DECISION DELEGATED TO HEAD OF PLANNING

Application No: H16-0510-22 **Applicant:** Mr & Mrs K Barfoot
Proposal: Proposed First Floor Extension
Location: 57 Apeldoorn Gardens Spalding
Terminal Date: 14th July 2022

CASE OFFICER ASSESSMENT

Scale	1:50 1:100 @ A1	Drawing No.	2212-02
Date.	MAY '22	Drawn.	J.C.

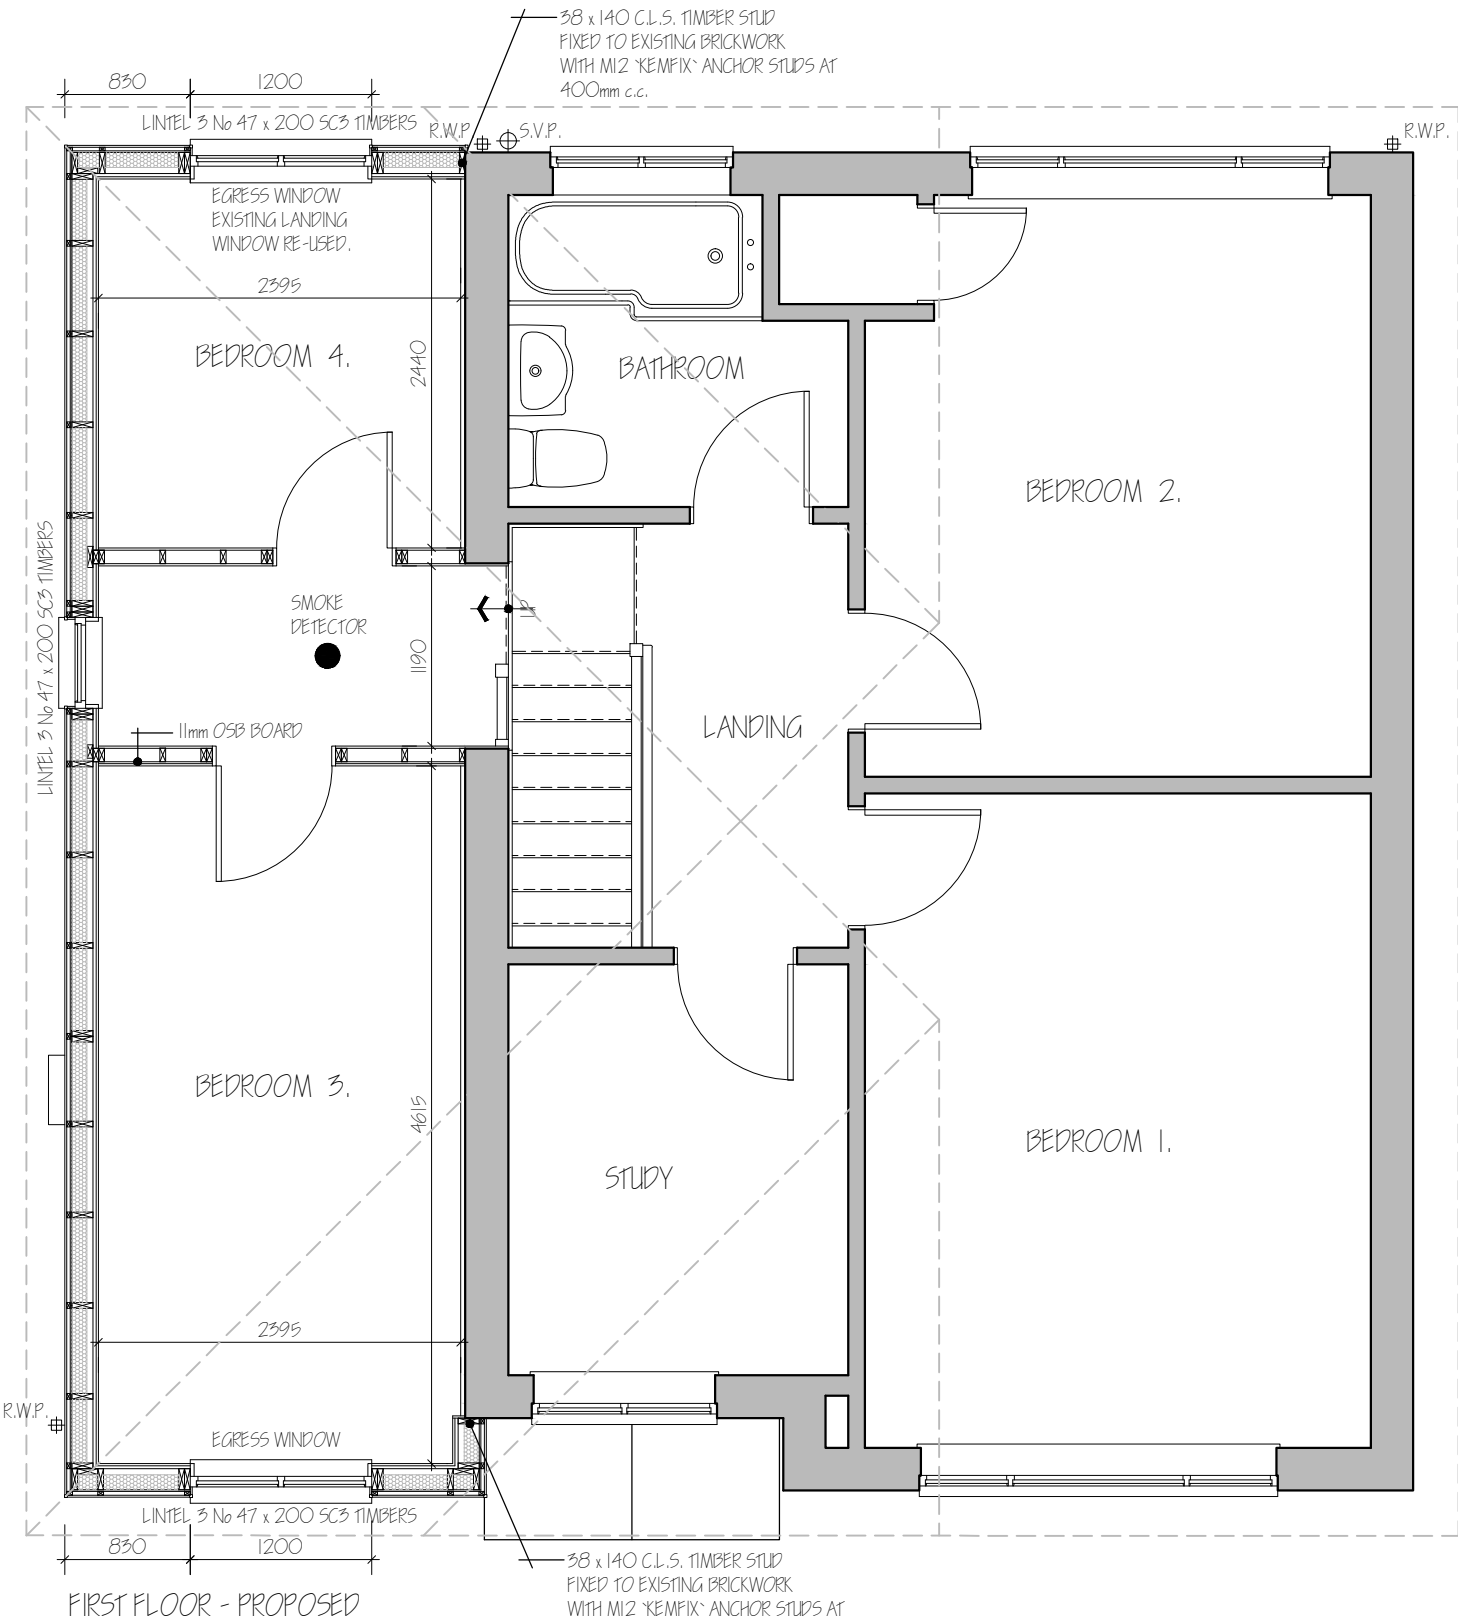
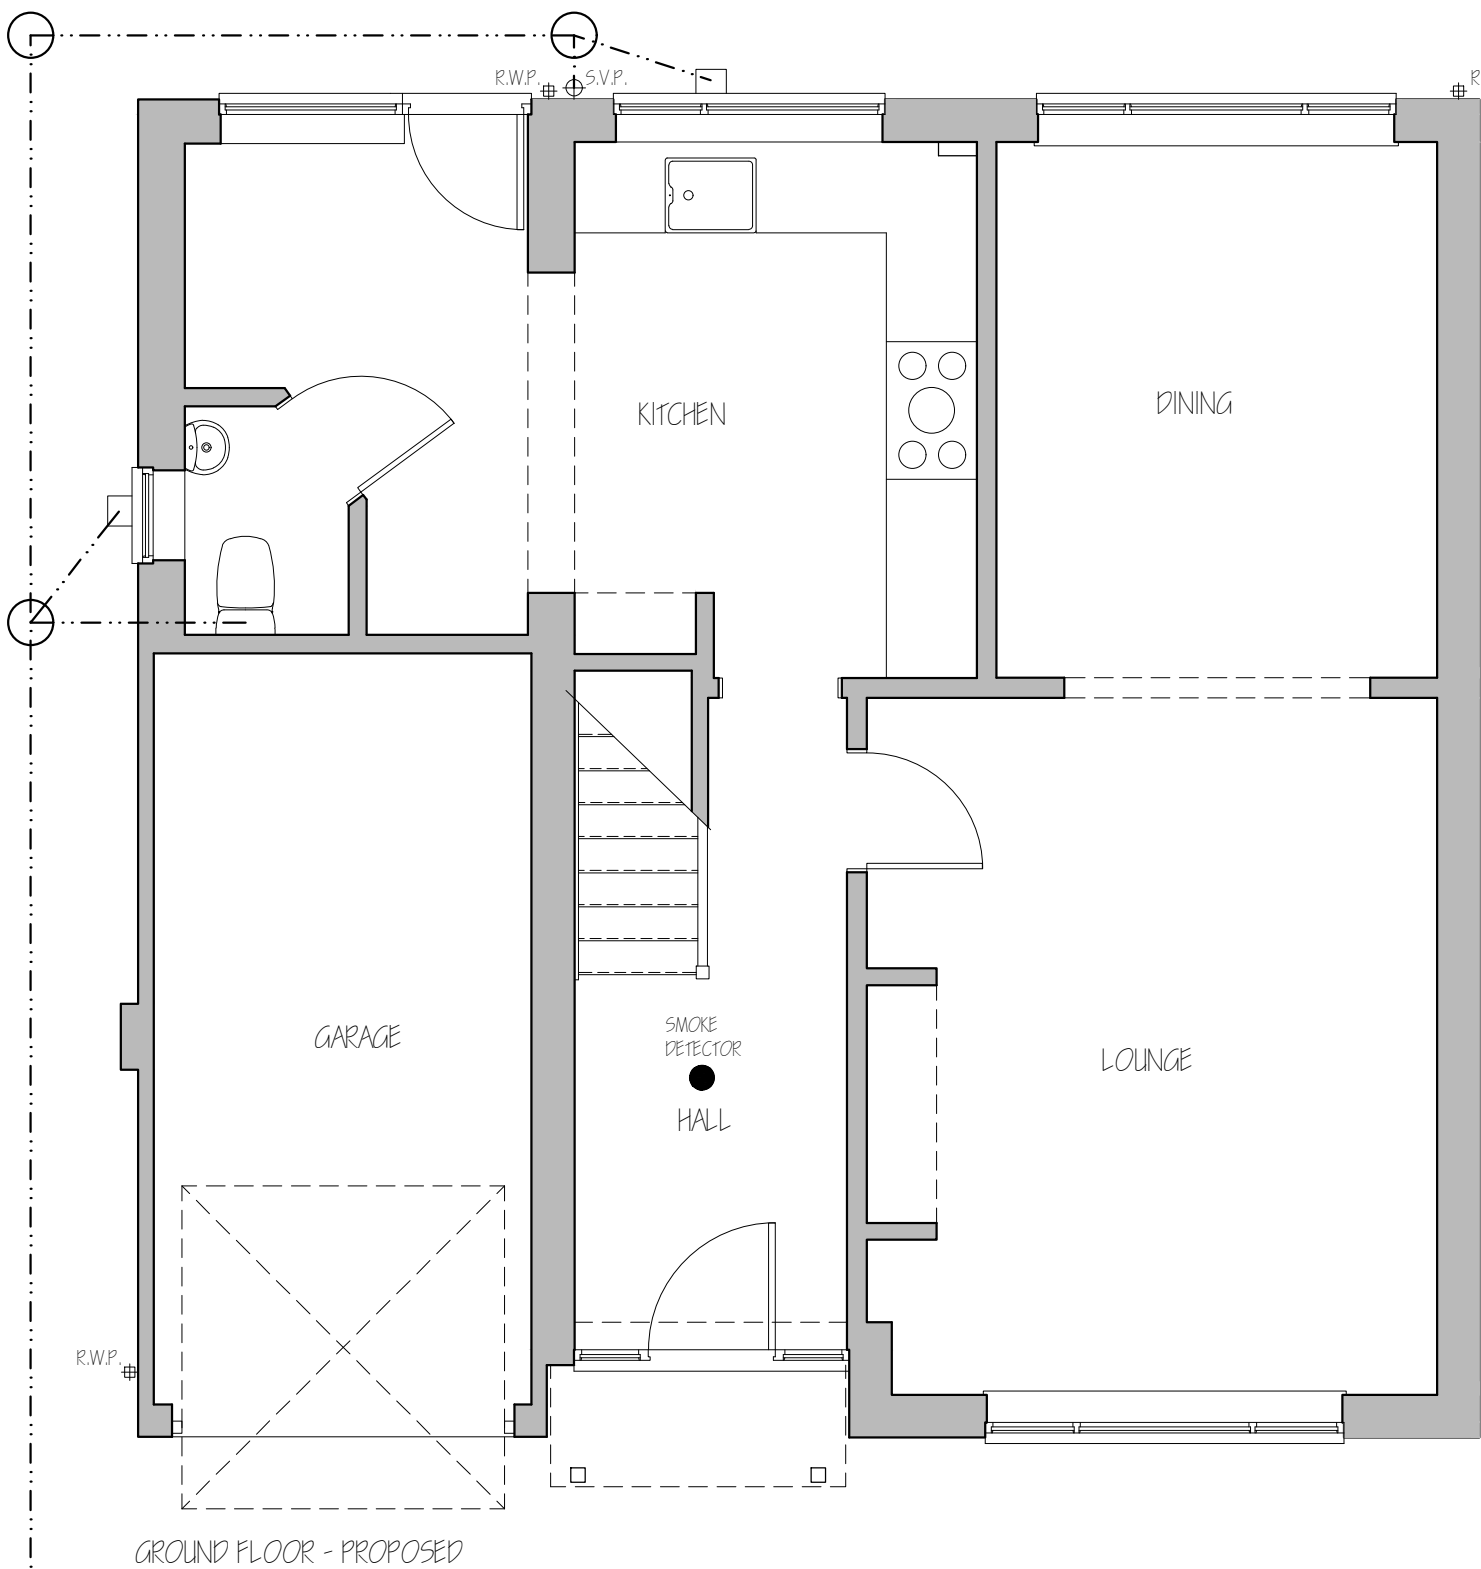
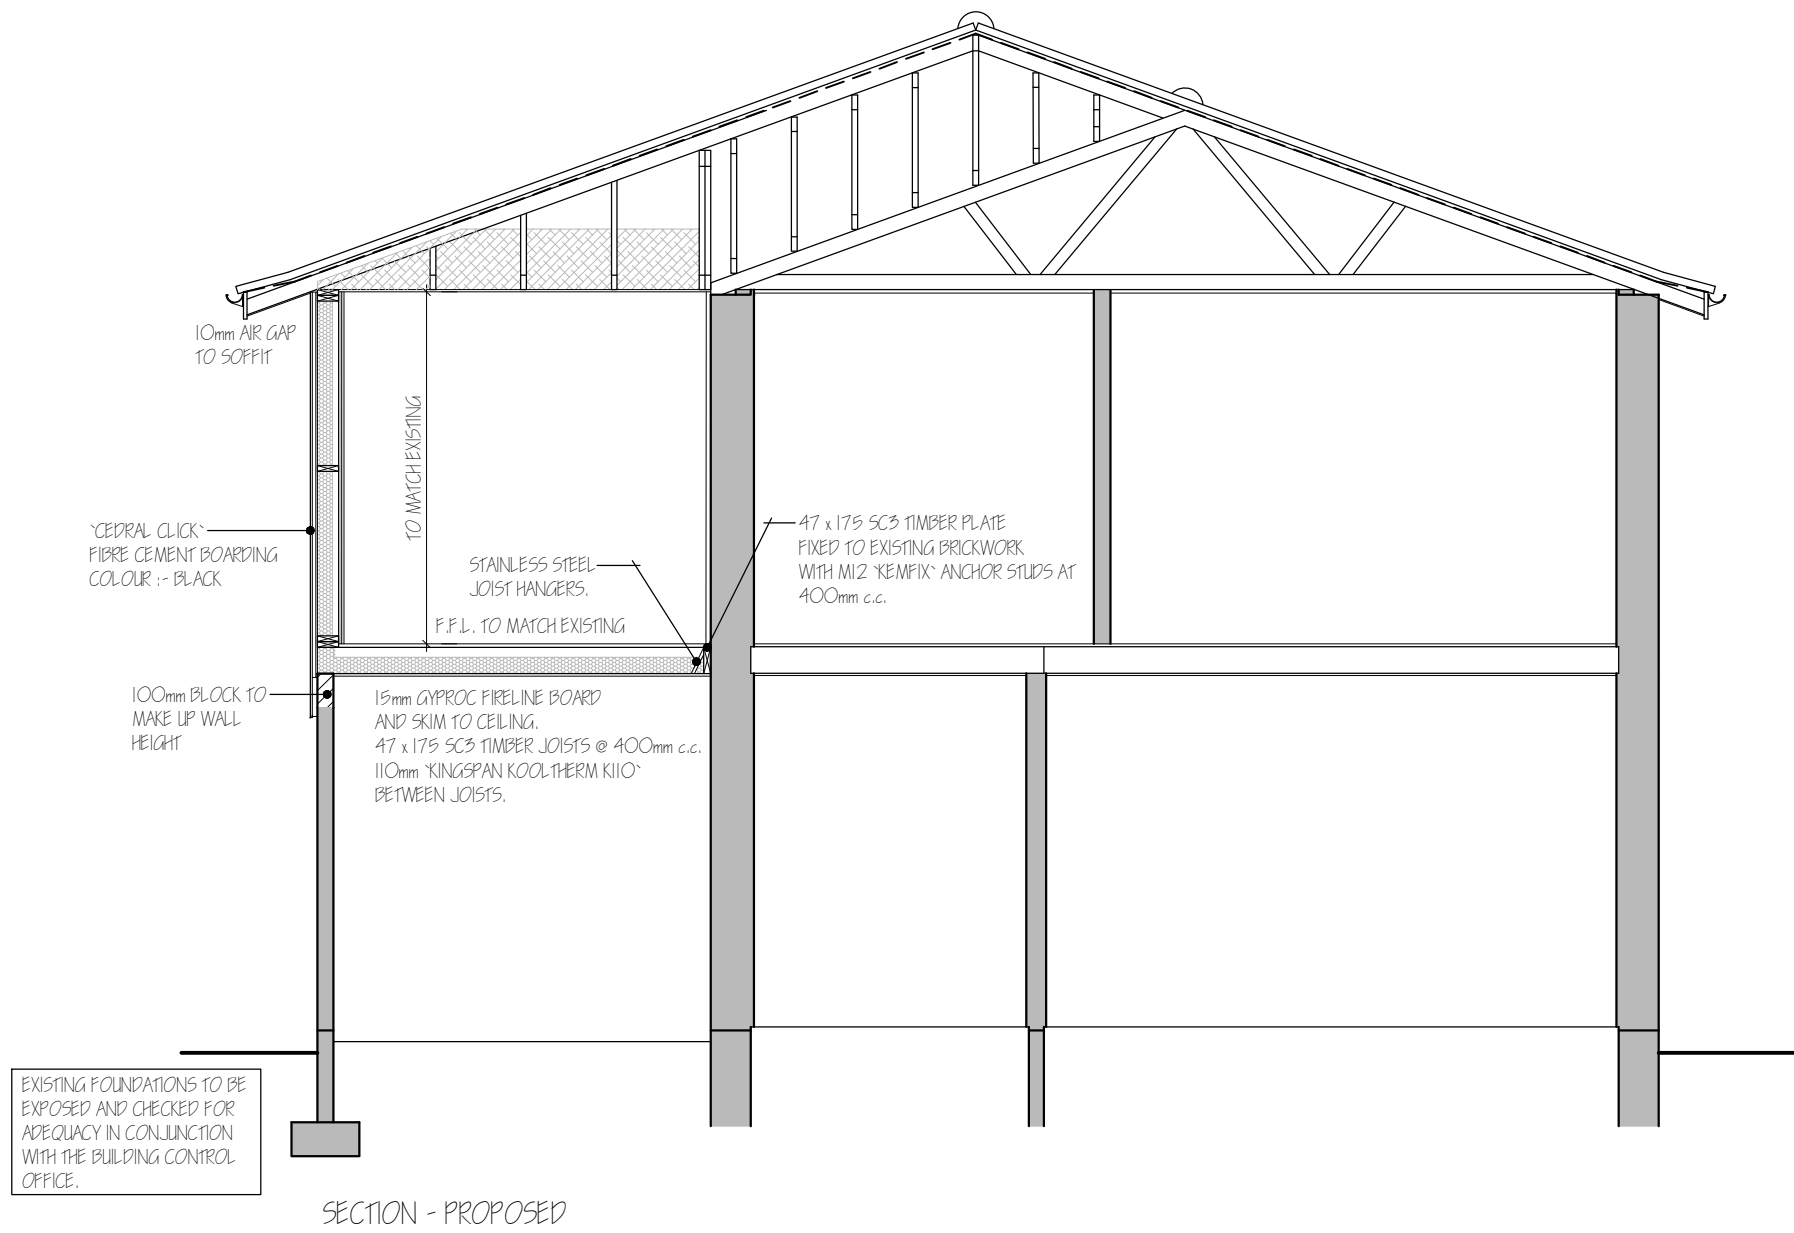
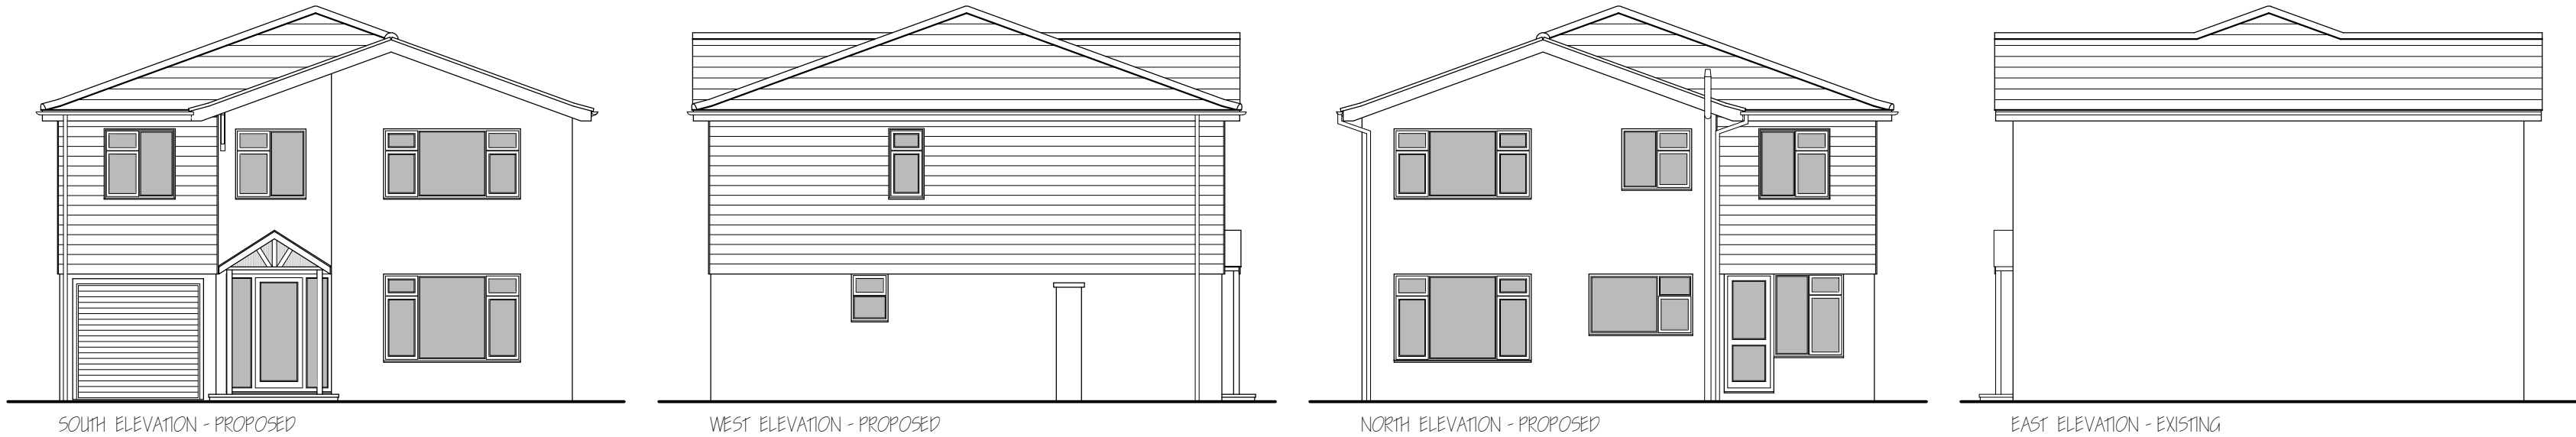
The proposed first floor extension would sit above the existing attached garage. The first floor extension would protrude from the side elevation by approx. 2.5m and have a depth of approx. 8.4m. Having regard to the existing dimensions of the house, the proposed first floor extension is acceptable in terms of scale, mass and bulk.

The roof structure will consist of a hipped roof which will sit approx. 500mm higher than the original overall height of the gable end roof. As much as a subservient extension roof would be preferred, the design of the roof is considered to compliment the overall roof design and is therefore acceptable in terms of visual amenity.

The first floor extension will be constructed from a timber frame, with the external materials made from black 'Cedral Click' or a similar Fibre Cement boarding on treated timber vertical battens. The existing landing window will be reused to the rear elevation of the proposed extension. The proposed concrete roof tiles and white upvc windows will match those to the existing. As much as the black fibre cement boarding is a contrast to the existing materials, there is also an example of external cladding seen at no.22 Apeldoorn Gardens and therefore, it would not be unduly out of keeping.

There are windows to the front and rear elevations of the first floor extension. There are properties to the rear but it would not appear that there would be a detrimental material impact as the proposed windows align with the existing rear elevation windows. The window to the front is

considered to be tantamount to a typical frontage relationship. There is a proposed side elevation window from the landing, but this would not have a material overlooking impact as the window and door on the opposing elevation would only appear to be to non-habitable spaces.

The proposed extension is not deemed to be overbearing and will not create unacceptable overshadowing when considering the positioning of the dwelling and the proposed side first floor extension. It would only impact upon the the neighbouring dwelling to the west which does not have windows to any habitable rooms on its side elevation. The extension would be set slightly forward of the front elevation of the neighbouring dwelling that side but not to such an extent that it would have a material amenity impact.
